**DELEGATED DECISION TO DETERMINE PLANNING APPLICATIONS**

**Reference No:** 2021/62/90253/W

**Site Address:** 43 , Gramfield Road, Crosland Moor, Huddersfield,  
HD4 5QB

**Description:** Erection of single and two storey rear extension and  
side porch

CLIENT	Mr Tariq Bashir		
ADDRESS	43 Gramfield Road, Crossland moor HD4 5QB		
PROJECT	Two Storey Rear Extension		
DRAWING	Proposed Layout and Elevation		
DRAWN	UH	DATE	Jan 21
SCALE	1.50@A1		
DWG No.	1539/02A		
STATUS	PLANNING

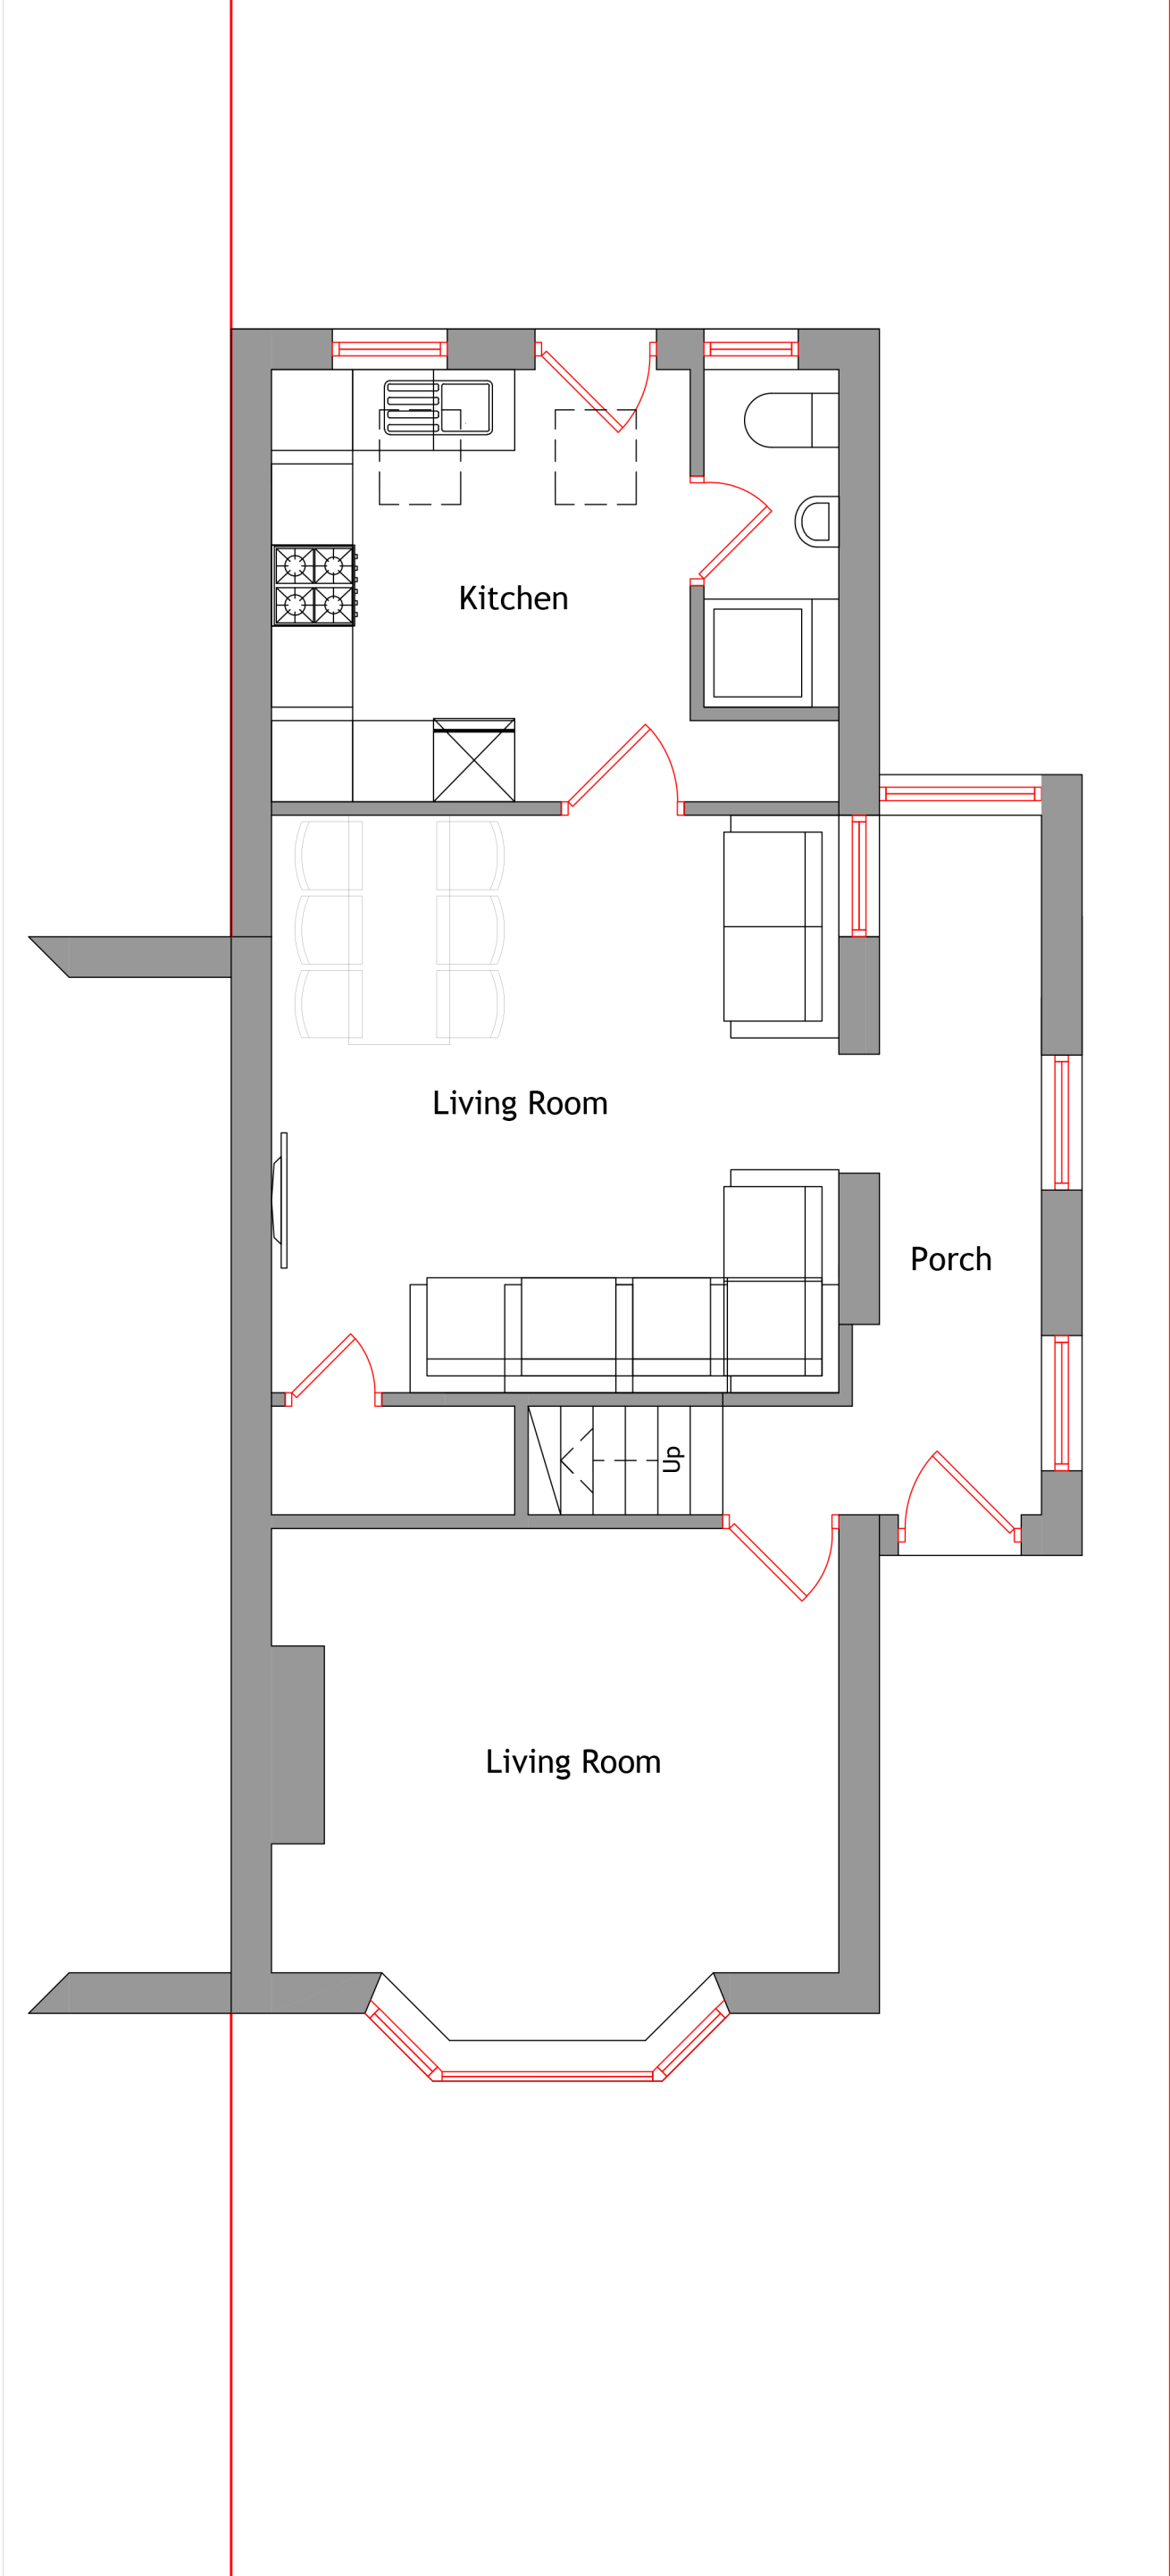
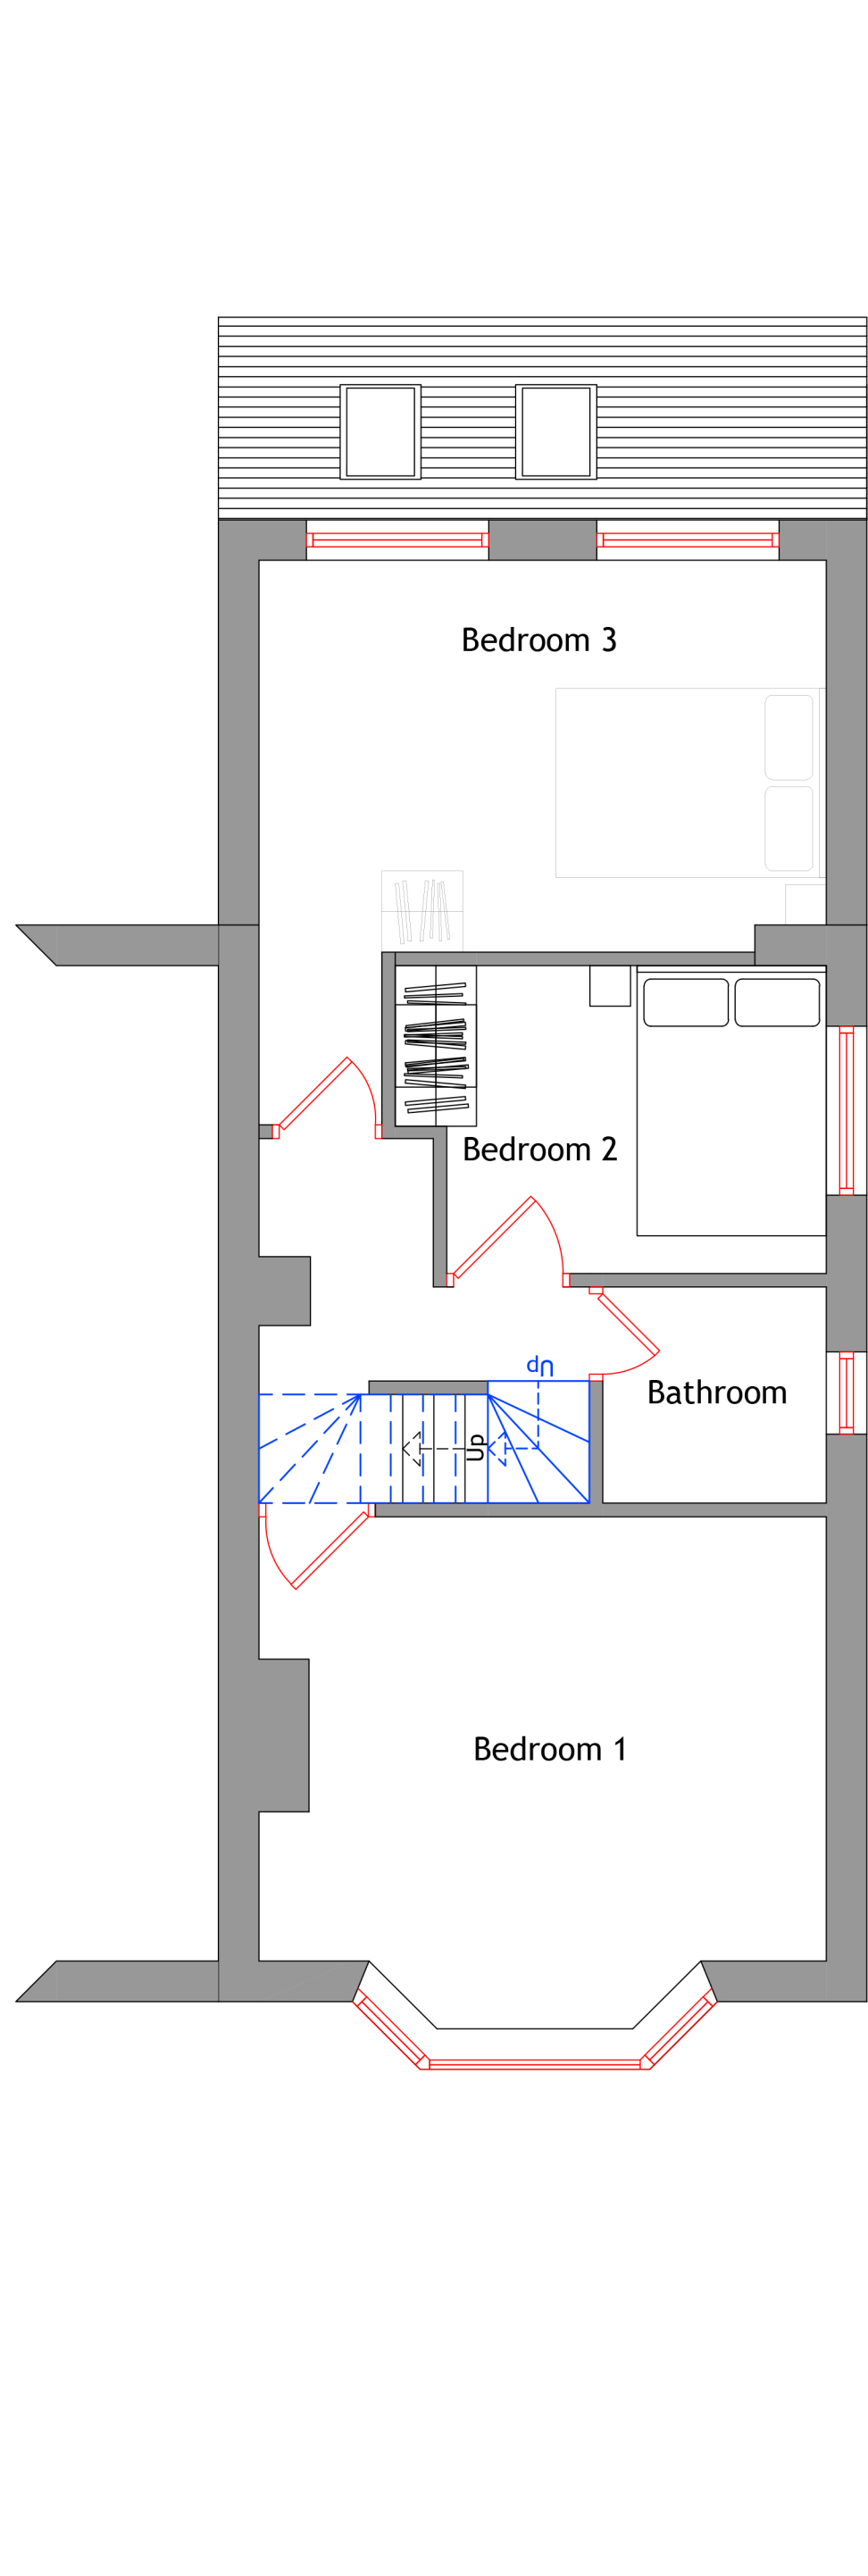
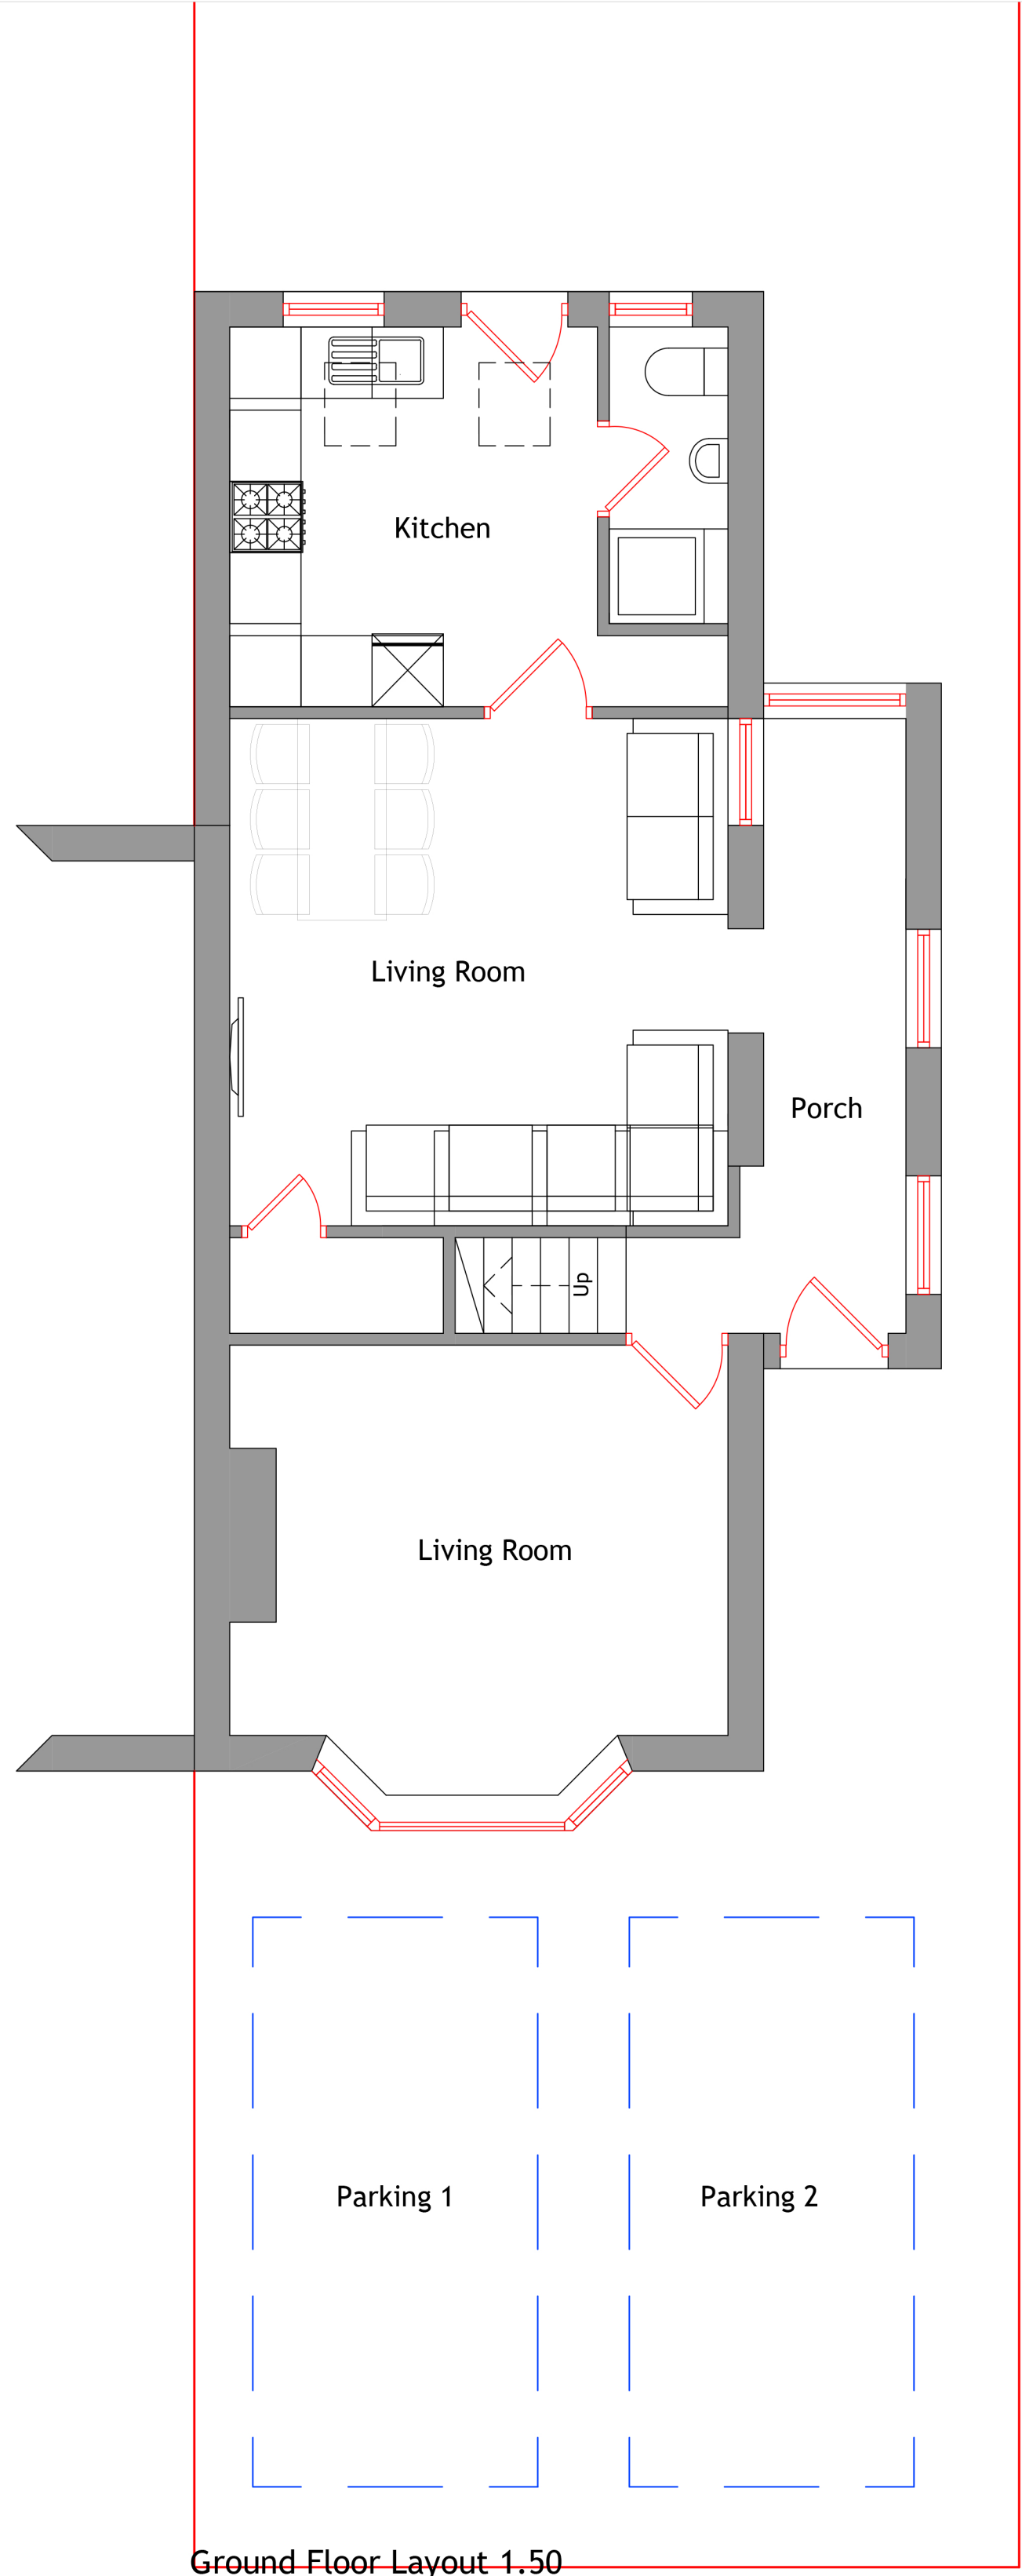
Officers have entered into various discussions with the agent regarding the projections of the single and two storey rear extensions and the impact in which they propose to visual and residential amenity. As such, a compromise has been reached to reduce the first floor to 3m and the ground floor to 4.5m.

Whilst it is appreciated that the majority of the works would extend beyond the rear elevation, it would not result in the overdevelopment of the site. Significant amendments have also been sought to reduce the footprint at ground floor from 6m to 4.5m. The single storey side extension would also

However, in this case, any overbearing is not considered to be detrimental, given the amendments sought to reduce the first floor projection to 3m. The ground floor extension will also be retained at a length no greater than 4.5m. As such, any impact on balance would not be detrimental. In terms of overshadowing, the proposal would lead to additional overshadowing from afternoon to evening, however the impact is on balance considered to be acceptable given the 3 metre first floor protection, the use of a hipped roof at first floor and lean to roof aiding in reducing the bulk of the extension.

| <b>Plan Type</b>                                                 | <b>Reference</b> | <b>Version</b> | <b>Date Received</b>          |
|------------------------------------------------------------------|------------------|----------------|-------------------------------|
| Proposed site plan, floor plans and elevations                   | 1539/02A         | -              | 2 <sup>nd</sup> April 2021    |

Given that the proposal has the potential to intensify the domestic use at the site taking the property to a 3 bed, officers have requested that a second on site parking space is provided to the front of the dwelling. In this case, an amended plan has been sought to show this, with the new space being at least 2.4m in width by 4.8m in depth. As such, the additional on site parking is welcomed.

Final amended plans were received on 2<sup>nd</sup> April 2021 to also include a second on site parking space.
